CITY OF ALBUQUERQUE

RE: **Wienerschnitzel**
2551 Corona Dr. NW
Request 60-Day Temporary C.O. - Accepted
Engineer's Stamp Date 5-10-16 (File: H11D069)
Certification date: 11-10-16

GRADING PLAN

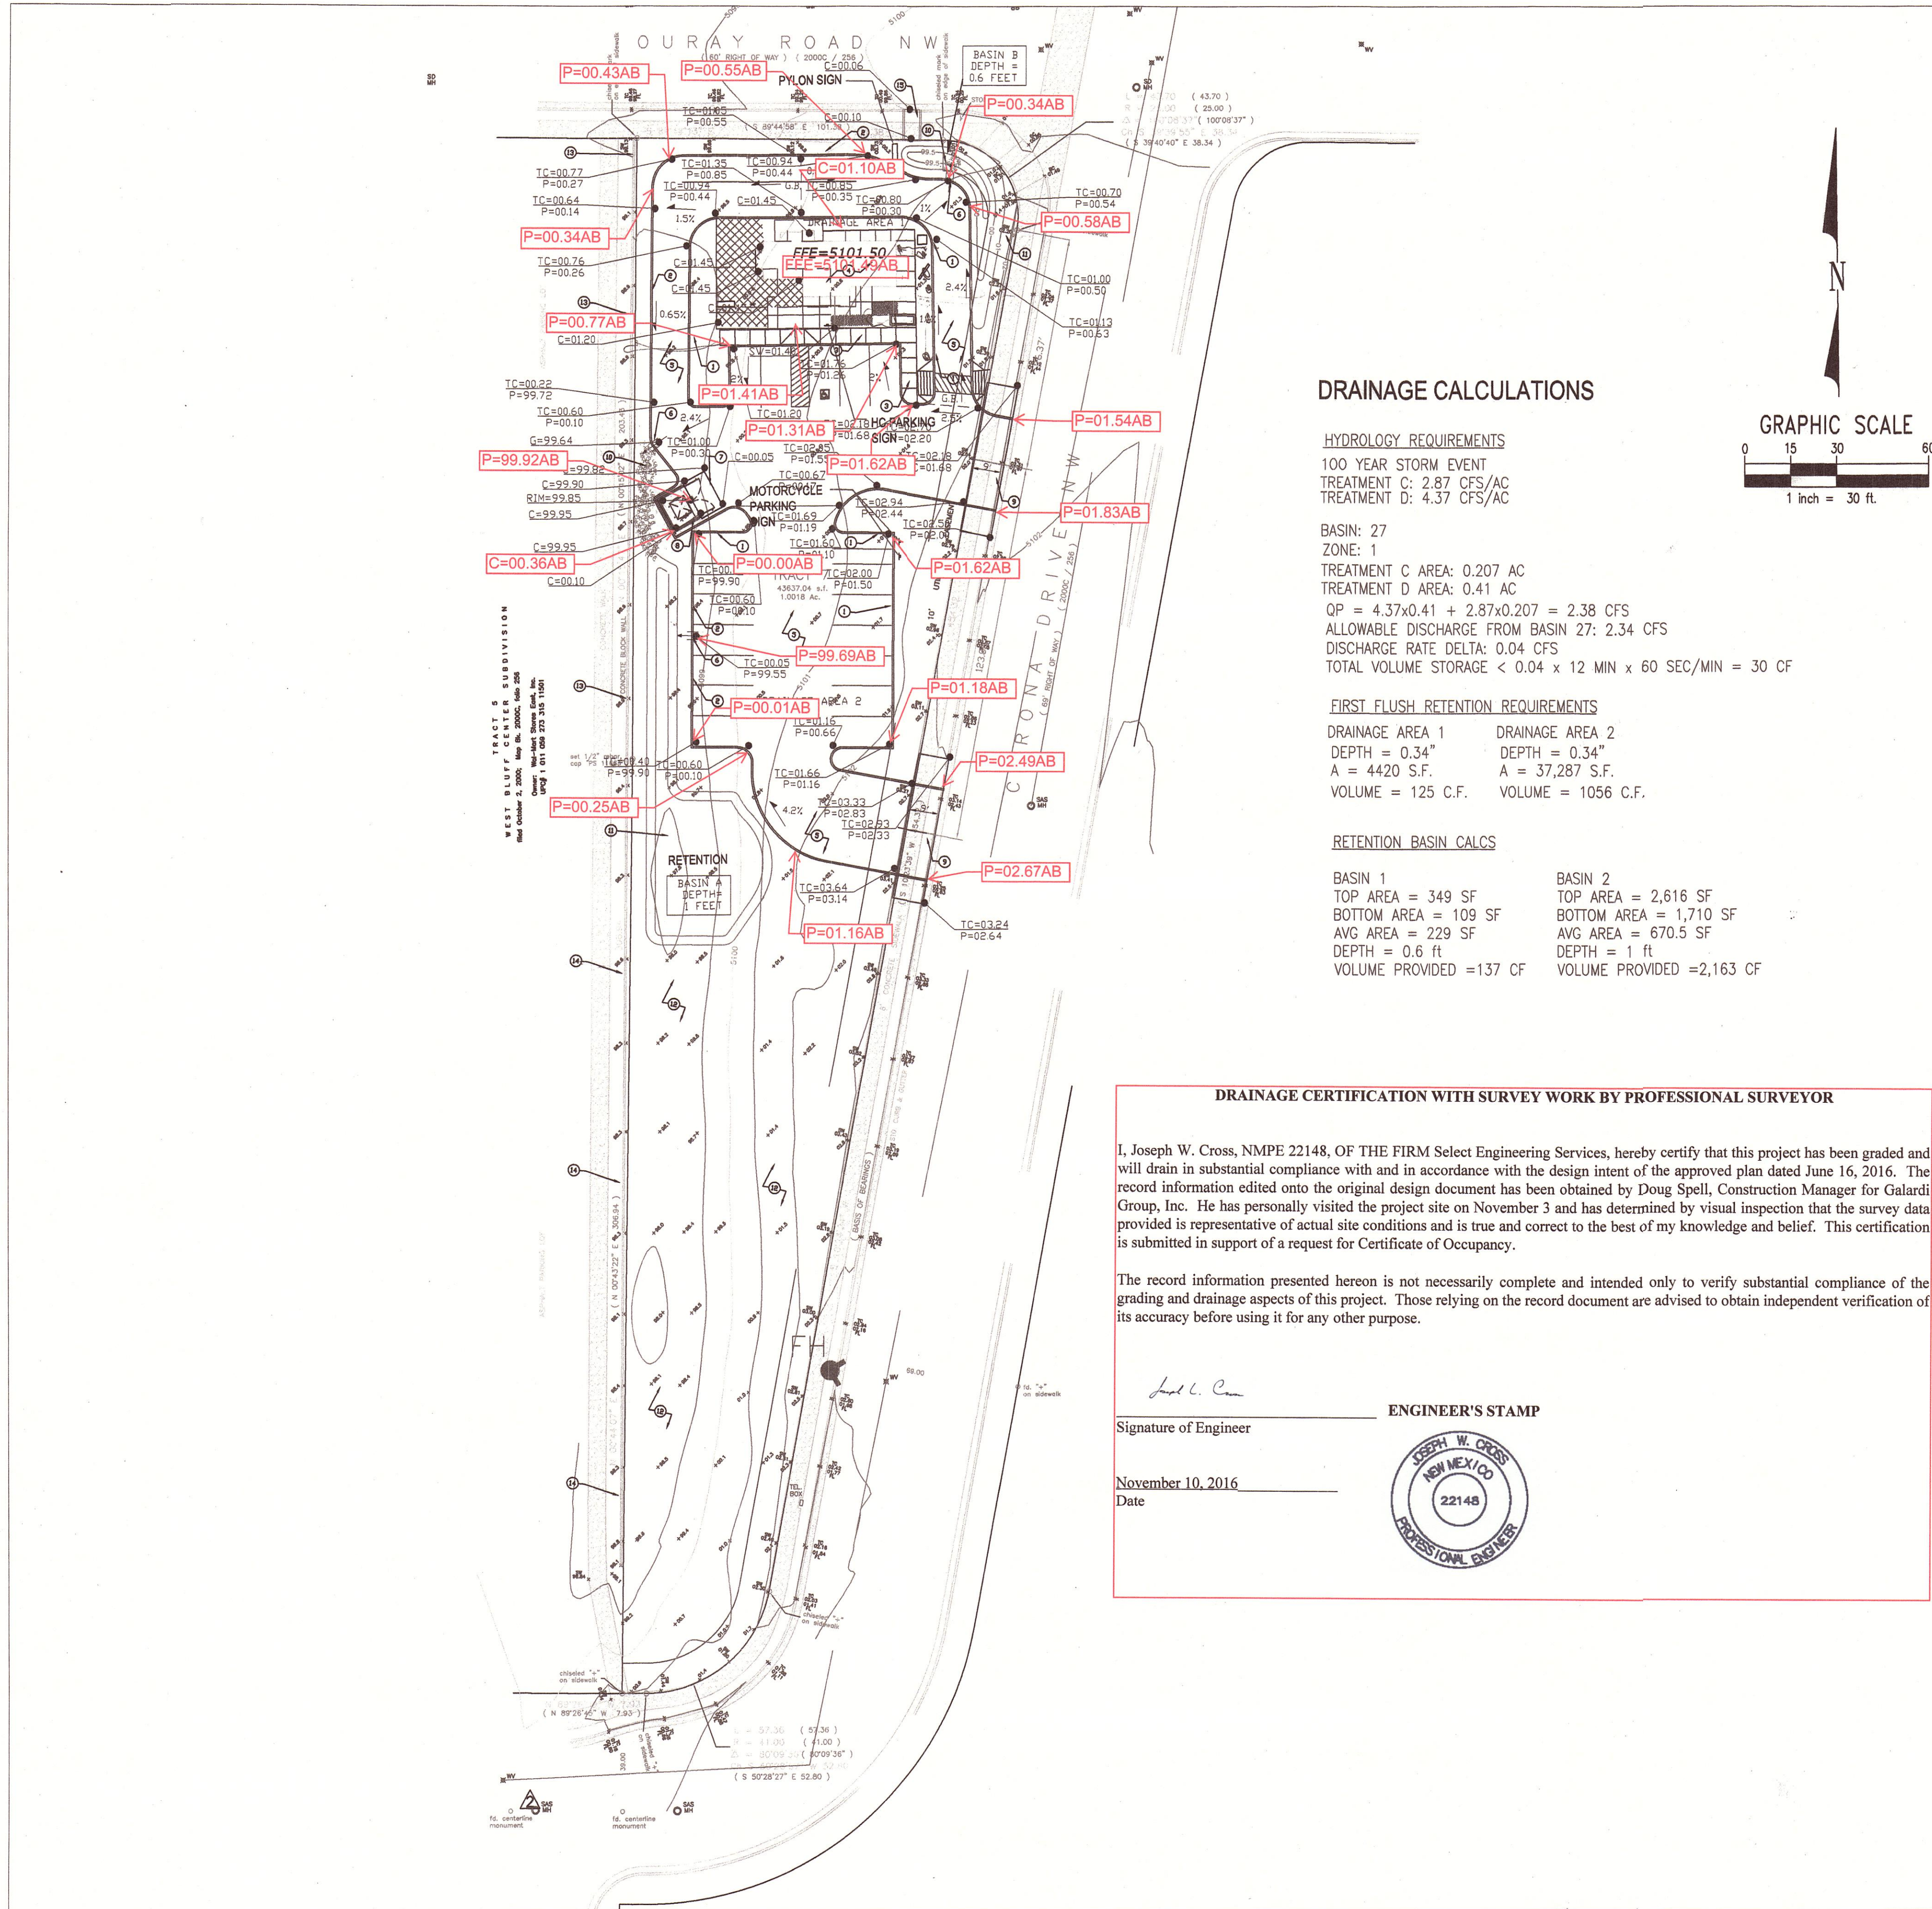
- The 3' opening in curb to the retention pond has created a swale that is causing erosion. Recommend fractured rock be place from the curb to the center of the retention pond.
- The sidewalk culvert is missing
